## Application for a Non-Material Amendment Following a Grant of Planning Permission

P/49/21/RES

GRP Trussed Apex Door Canopy

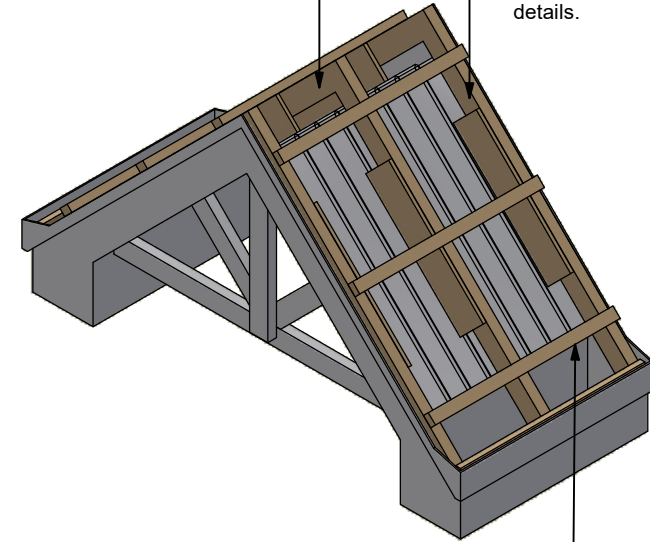
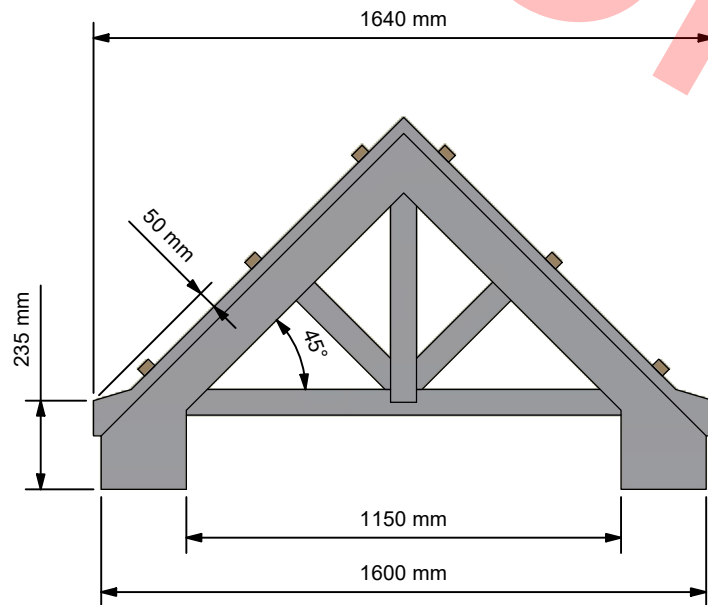
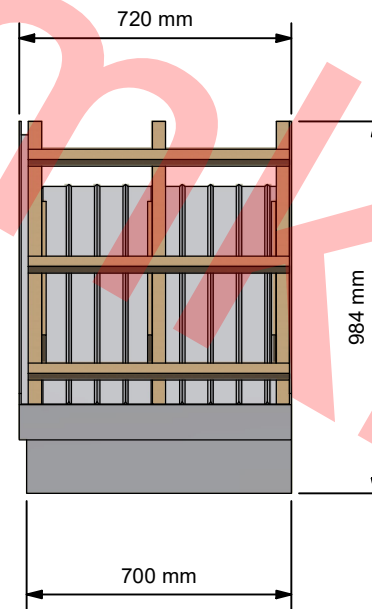
Change the canopies for plots 93 and 94 from flat style to apex style
